From: Fiona Fitzgerald
Sent: 15 January 2018 10:36
To: Planning.Responses
Cc: Anita Gardner
Subject: WA/88/17/PL

1. The application letter states "there are no proposed works to the attached Burger King unit" but the plans show a 48 sq m triangular extension. Which is correct? Is Burger King being extended or not?

At present, due to the issues raised above, Environmental Health would **object** to this application.

1 PROPOSED GENERAL ARRANGEMENT PLAN

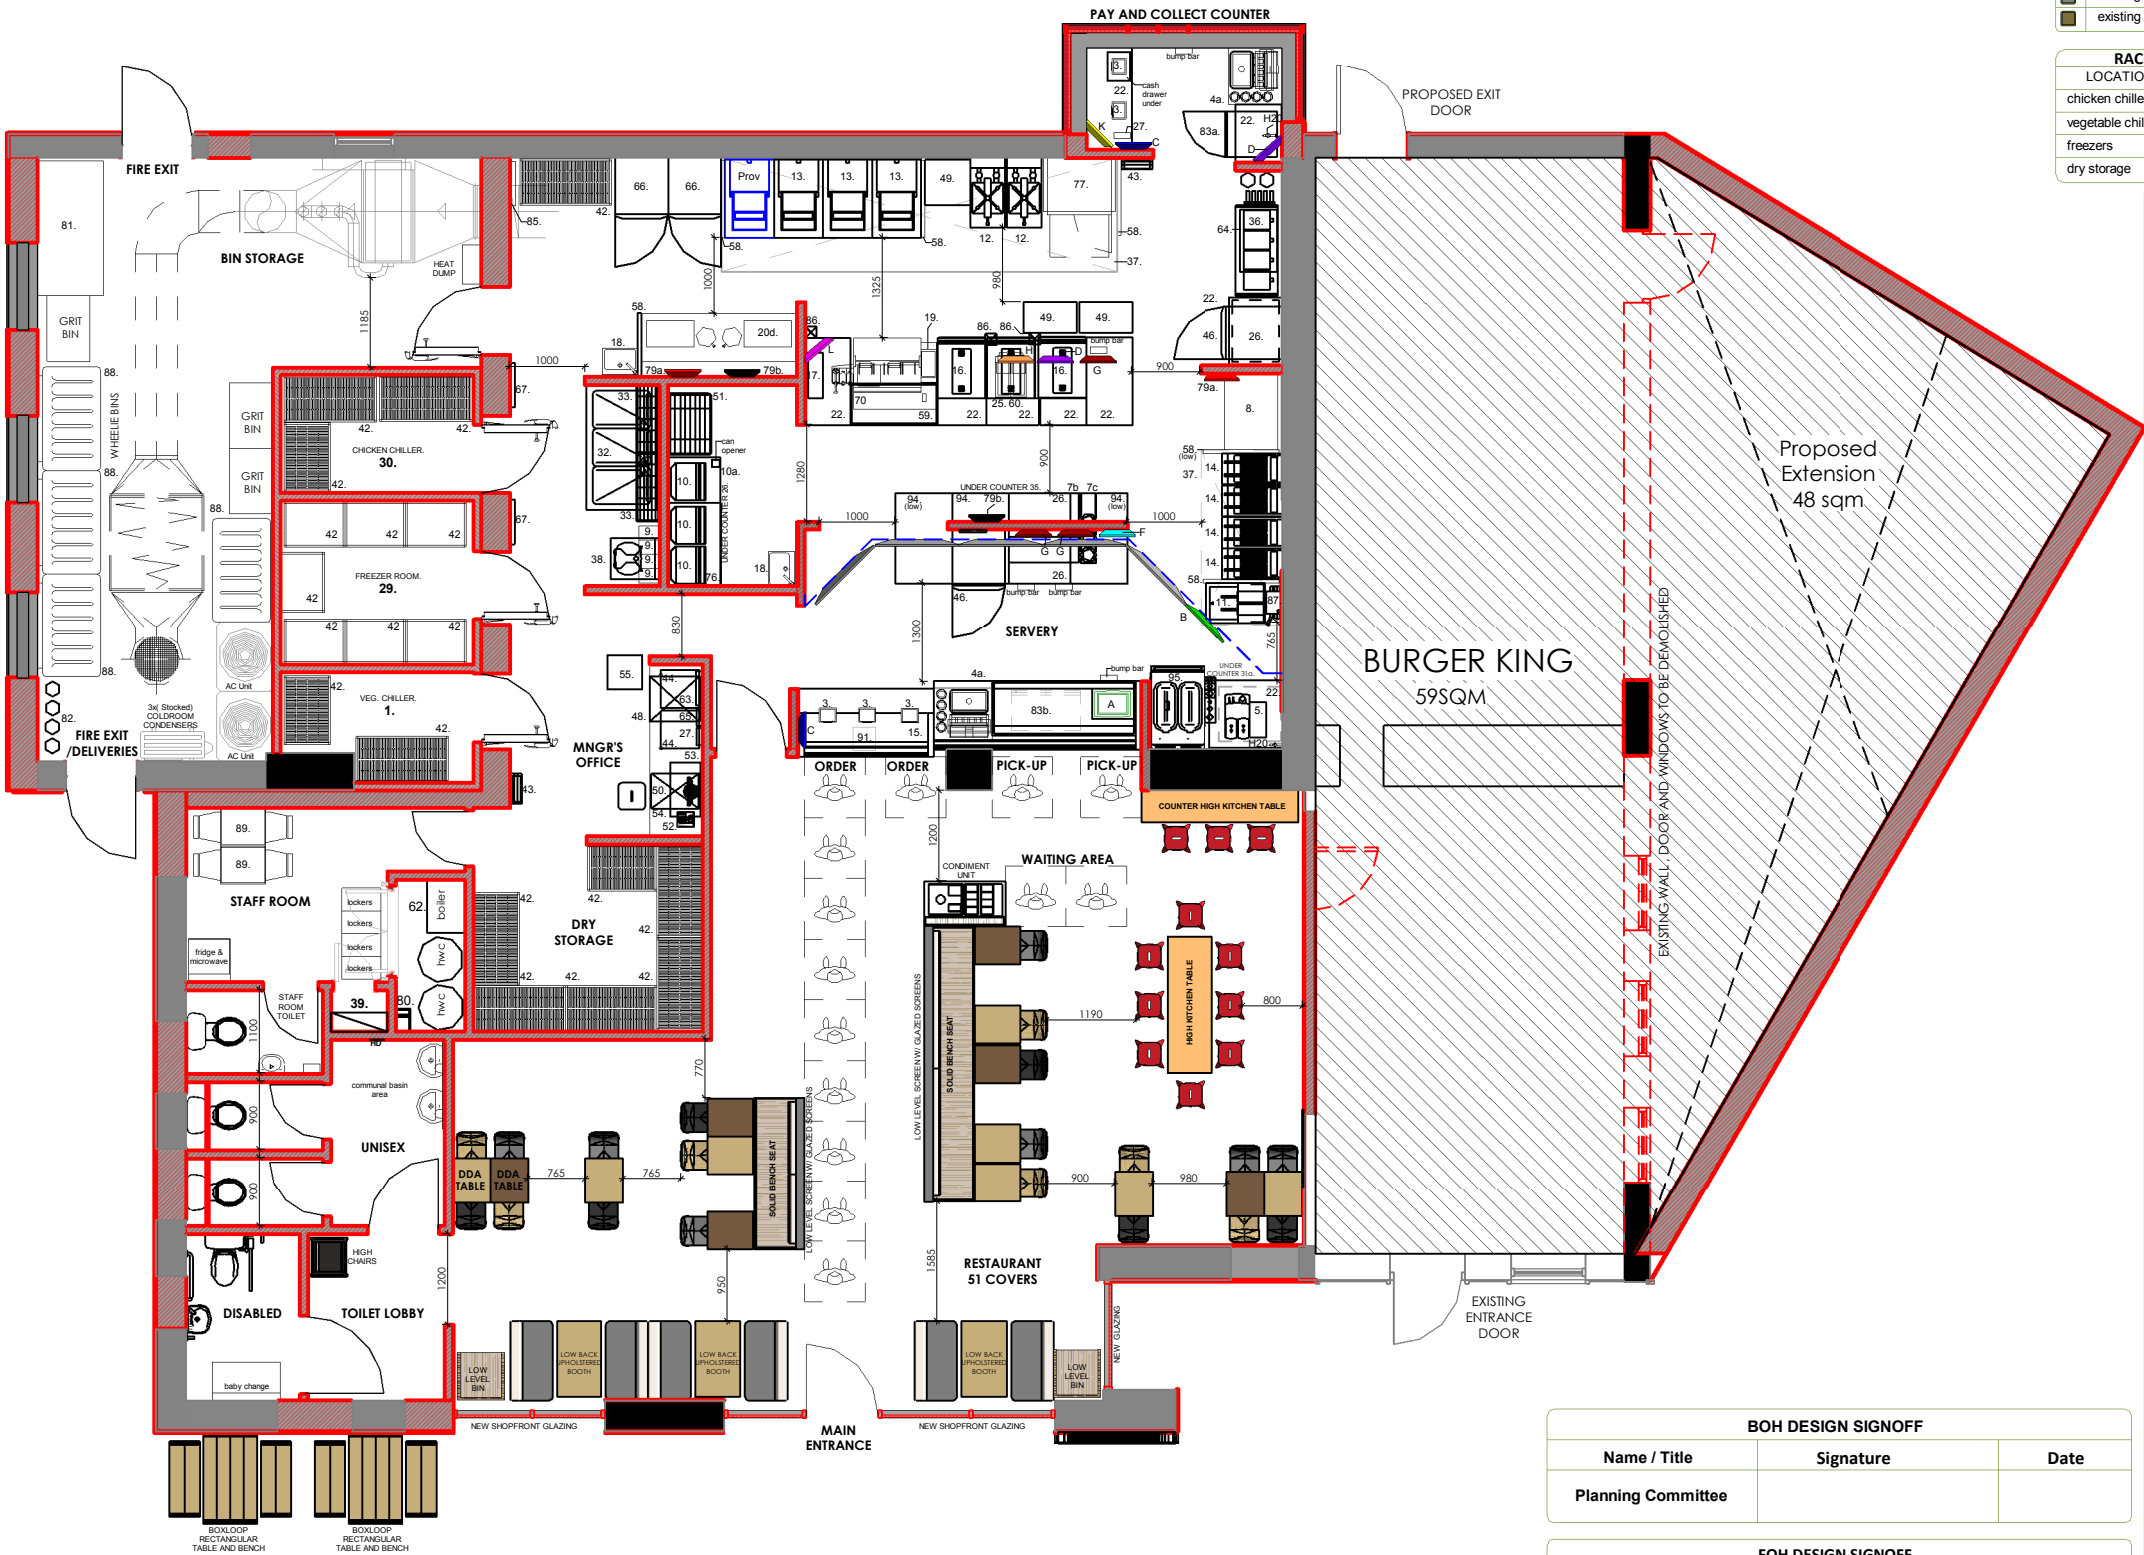
4. Can the applicant confirm whether they consider the number of wash-hand-basins in the KFC kitchen to be sufficient (2 no.).
5. Please could the applicant confirm the number of covers for this premises, so that Environmental Health can assess whether the sanitary provision is sufficient.
